May 15, 2008

**Re: Revised Submission Materials
Portland Museum of Art Spring Street Parking and Garden Project**

As you requested, we submit the attached PDF images of the plans for the Spring Street project. These plans have been revised to include the comments set forth in your memo as well as comments made by the Planning Board at the workshop on May 13, 2008. The specific revisions to the plans are as follows:

7 BIKE RACK DETAIL  
L5.2 NOT TO SCALE

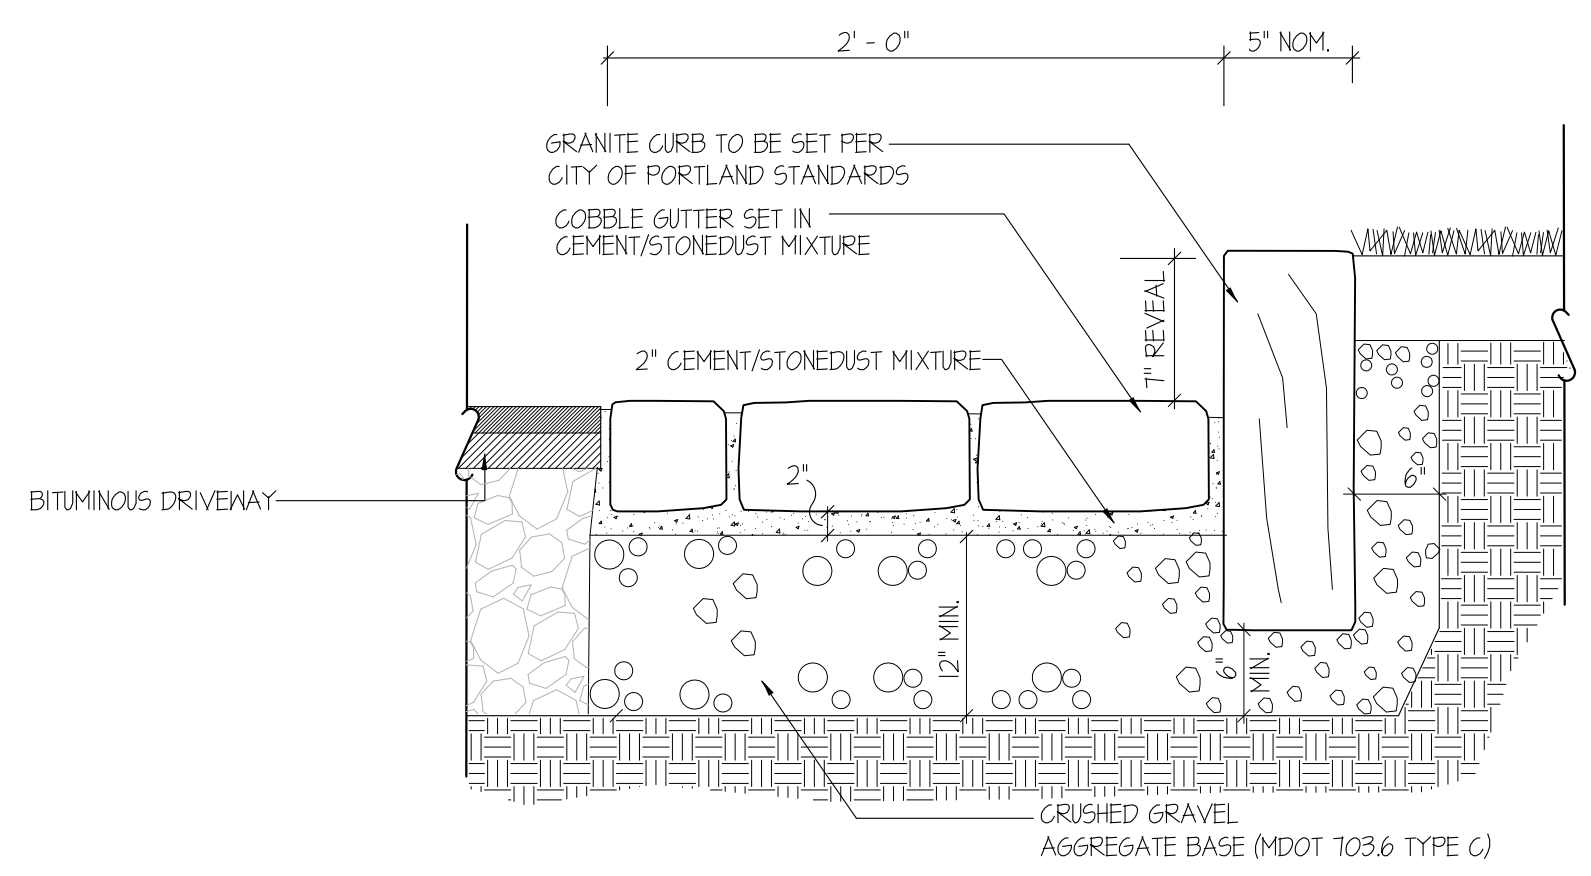
The previous submission included a detail for the proposed bicycle rack that is located on the west side of the Clapp House. We have revised that detail to provide a lower profile bicycle rack.

Title: <b>Existing Retaining Wall: Elevations and Details</b>	
Job No.: 688	Dwg. No.
Date: 28 March 2008	<b>L5.3</b>
Scale: As Shown	
Drawn: MK	
Checked: SM

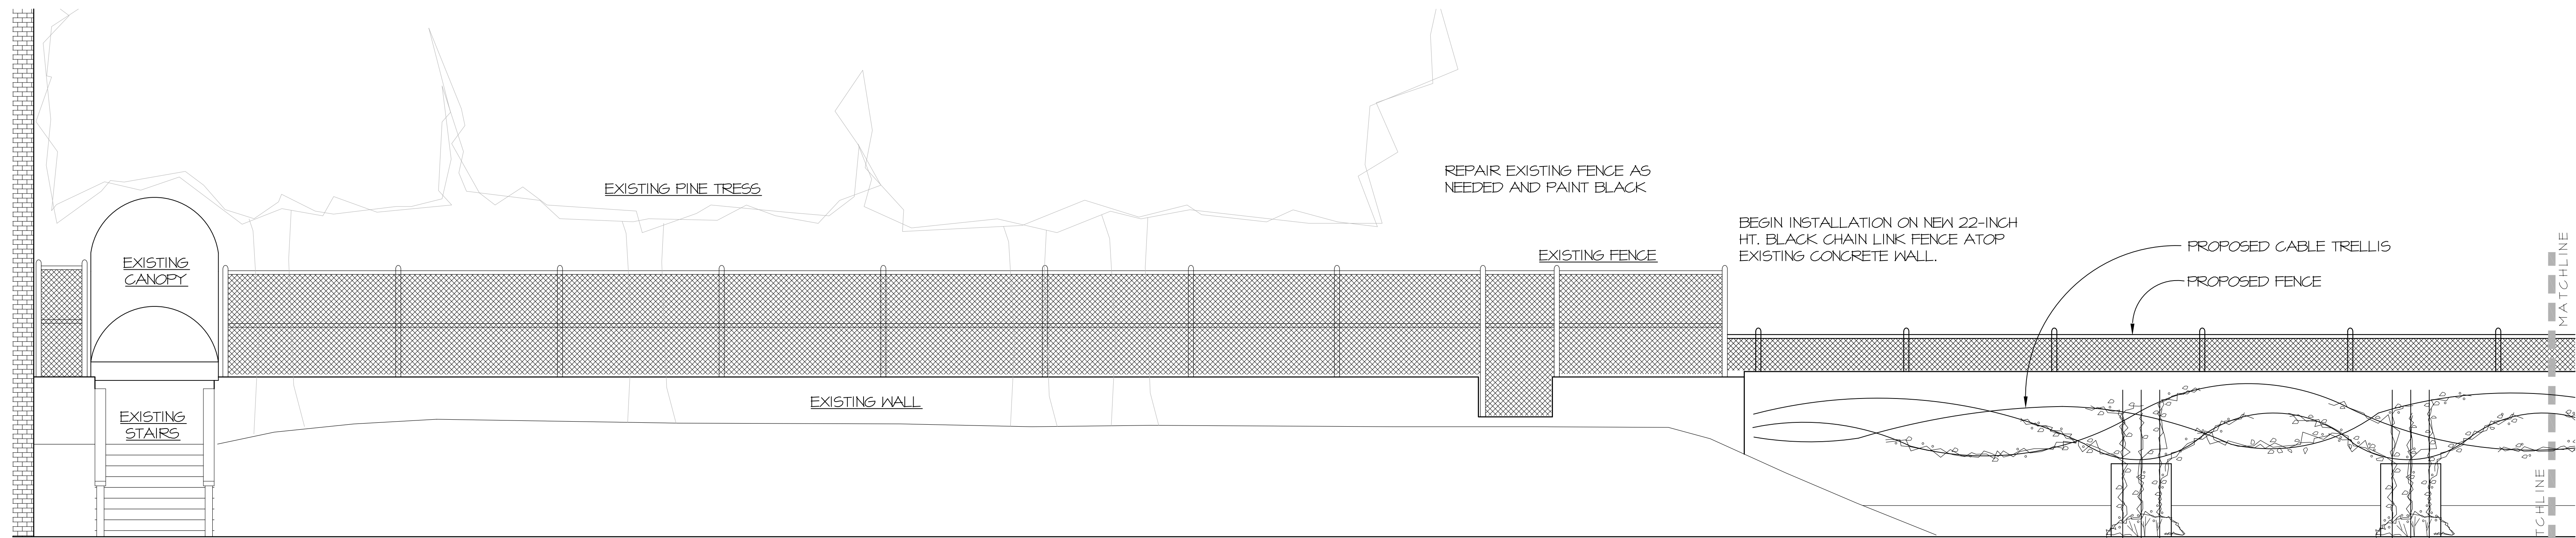
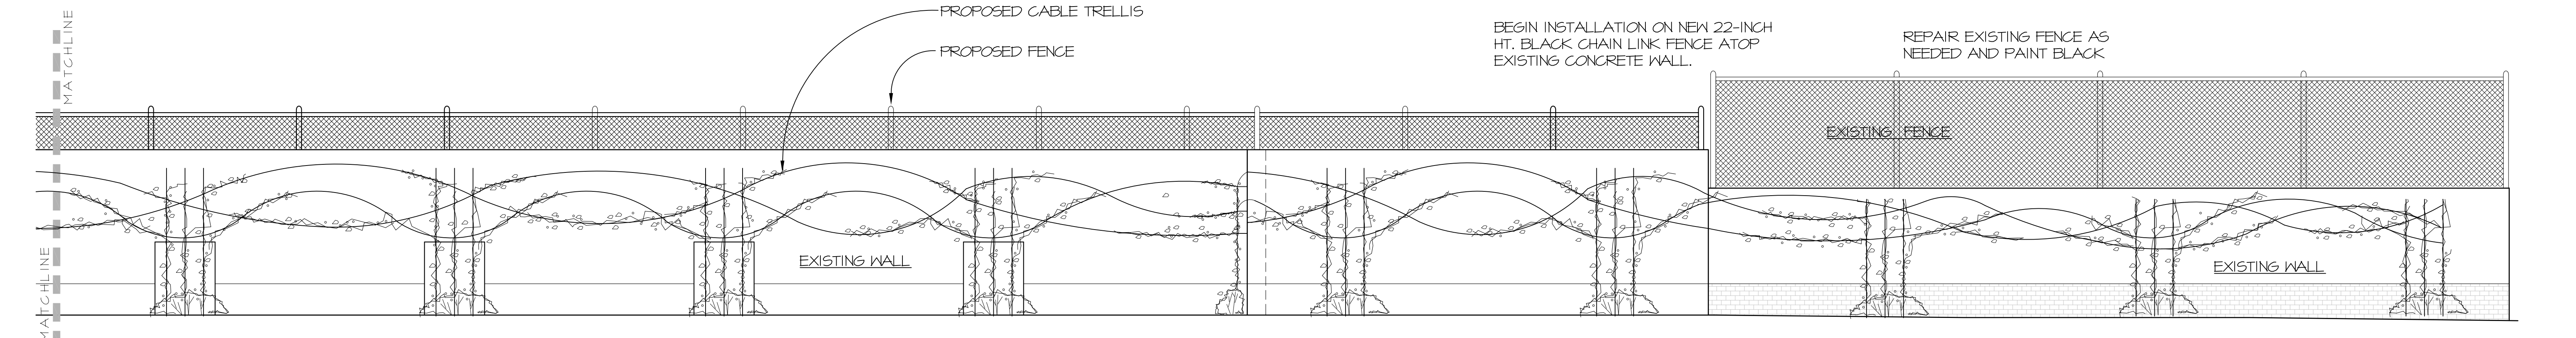
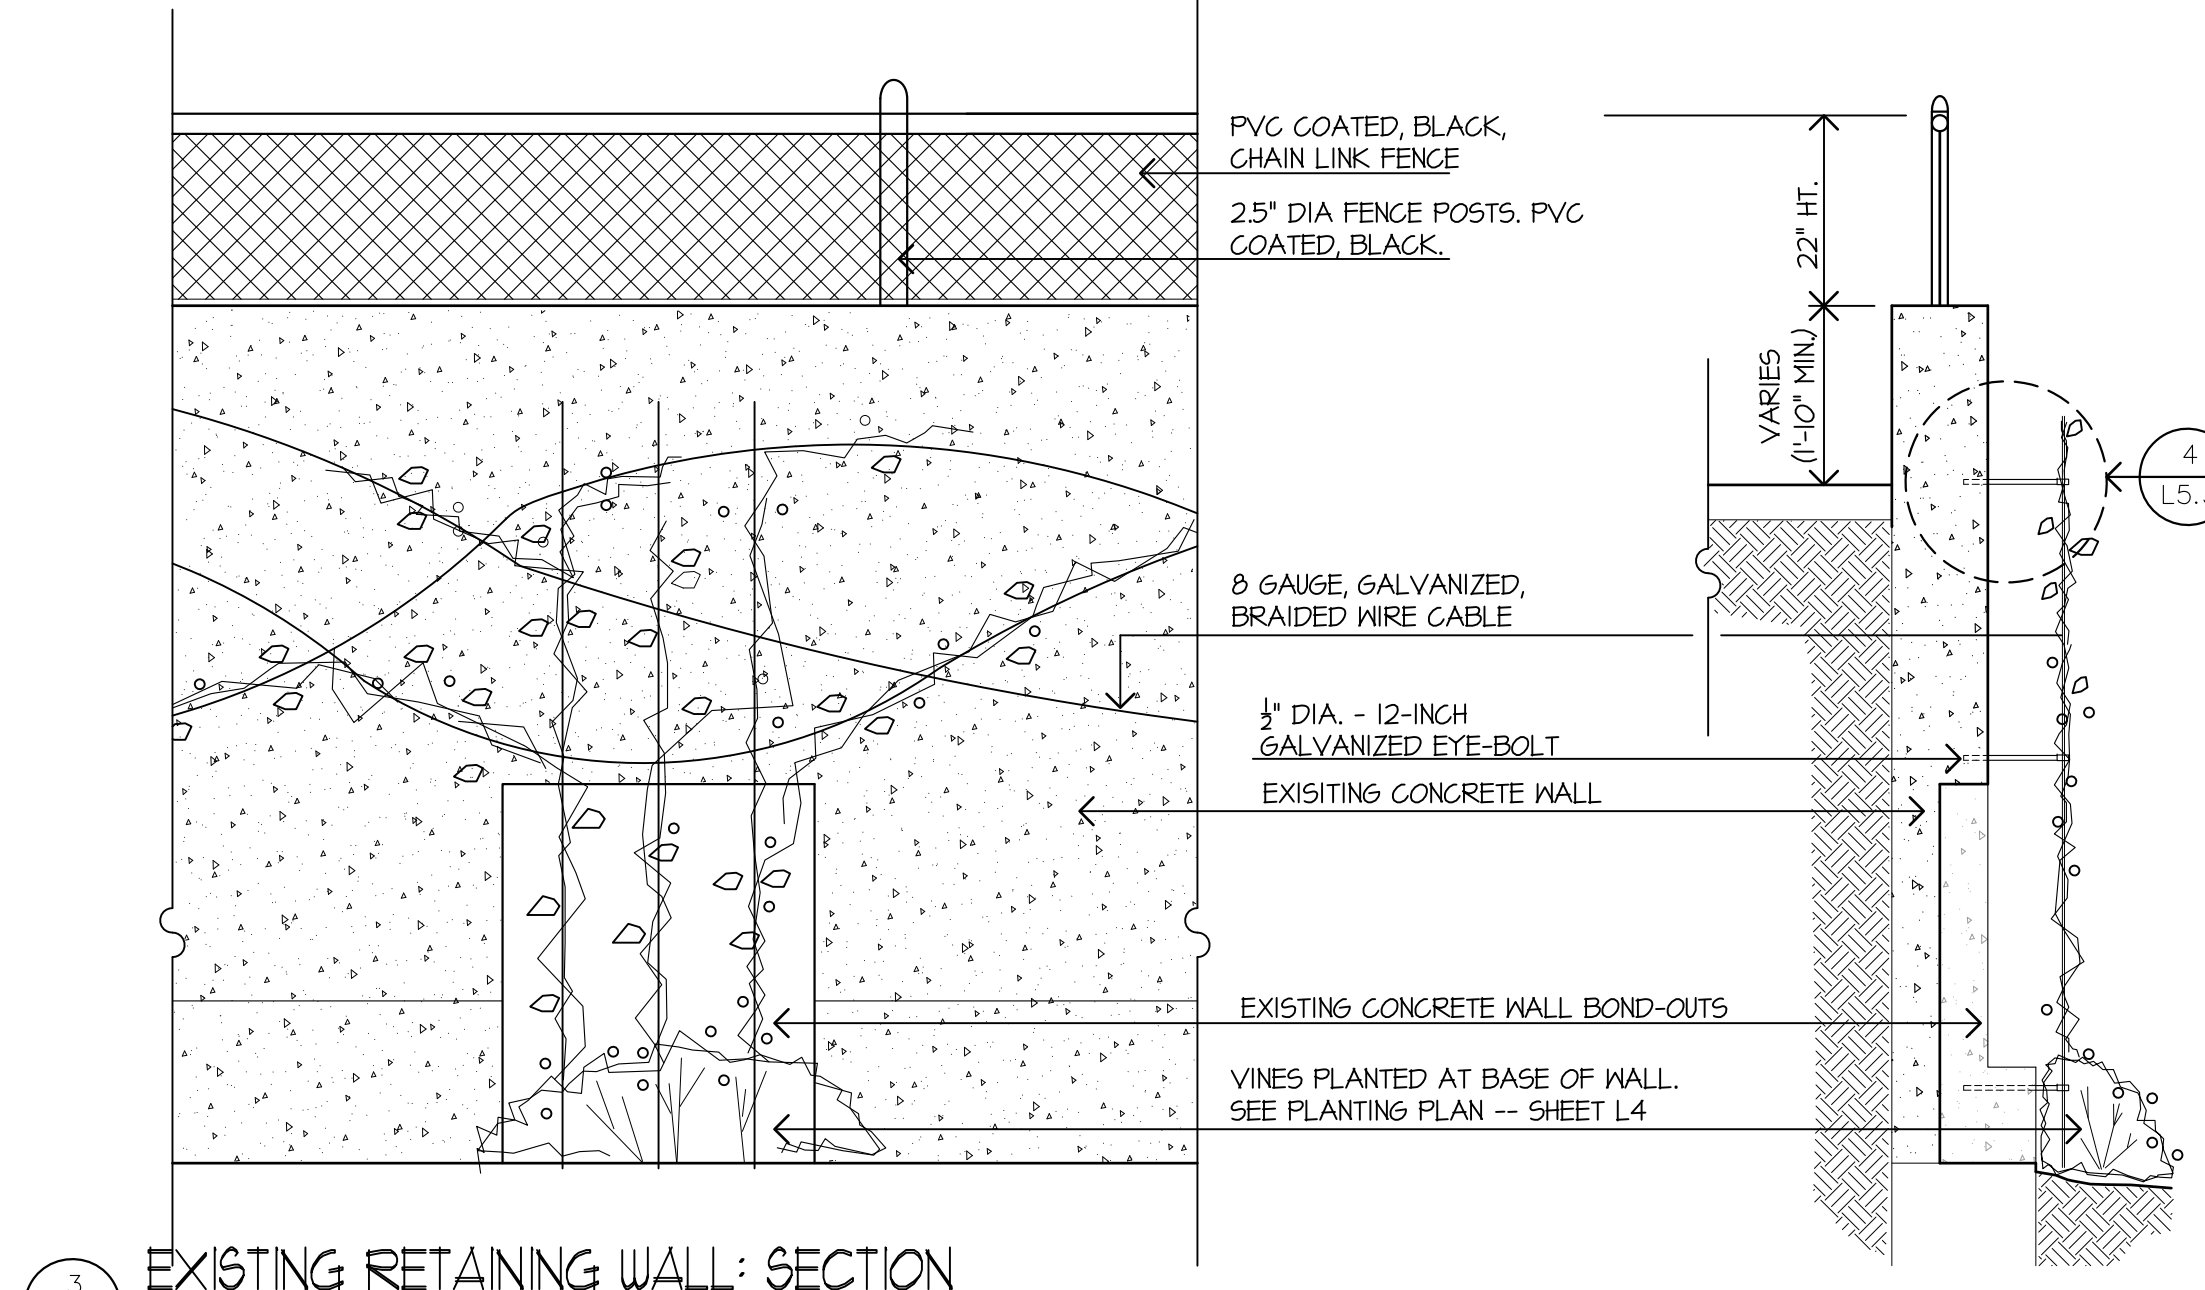
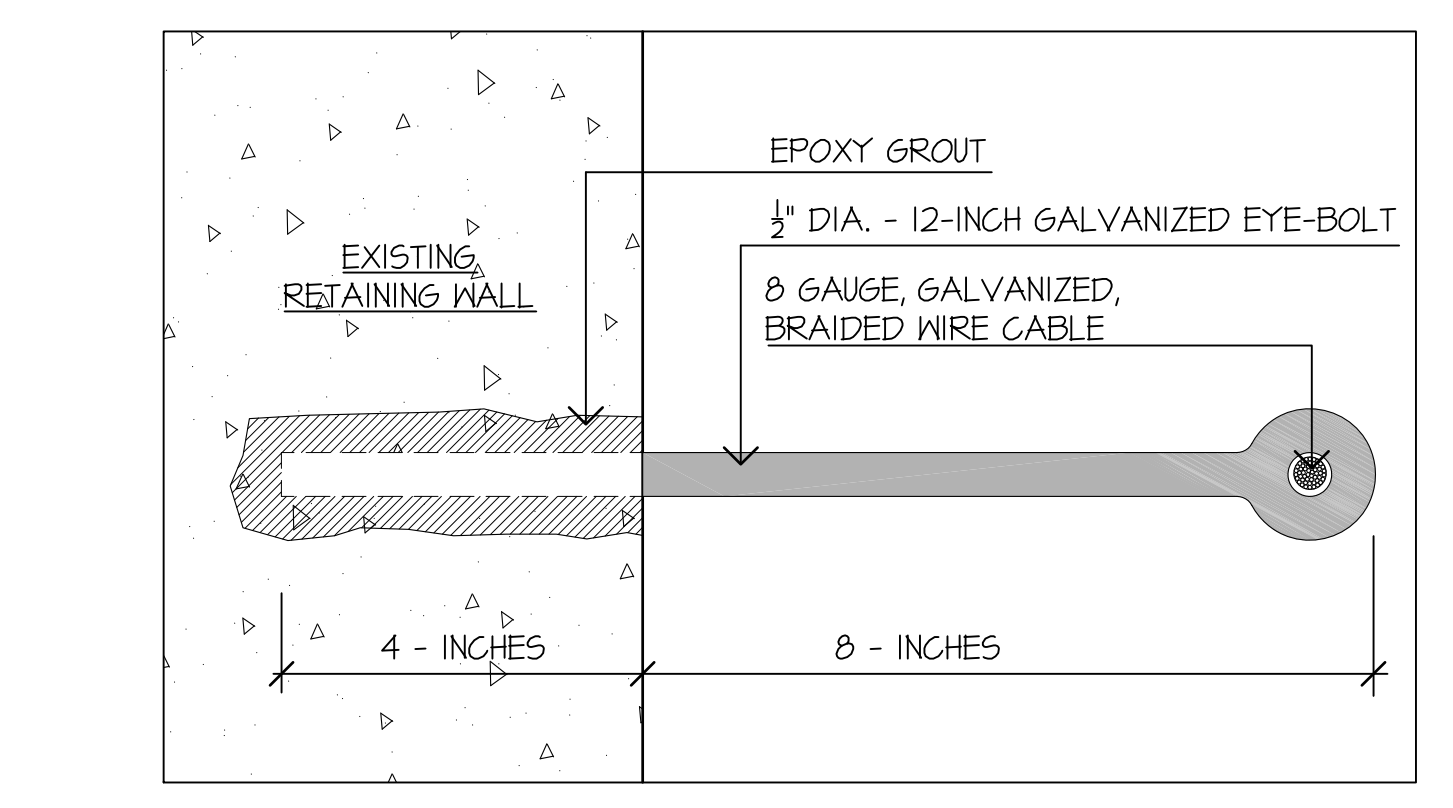
3. **Treatment of the rear wall:**
The information that was presented to the Board for the treatment of the rear wall has been included on a separate drawing, L5.3, submitted in this package. As presented to the Board, we will be installing cables on the rear wall as an armature for the vines. The layout and construction details for the cables are shown on the newly inserted project sheet.
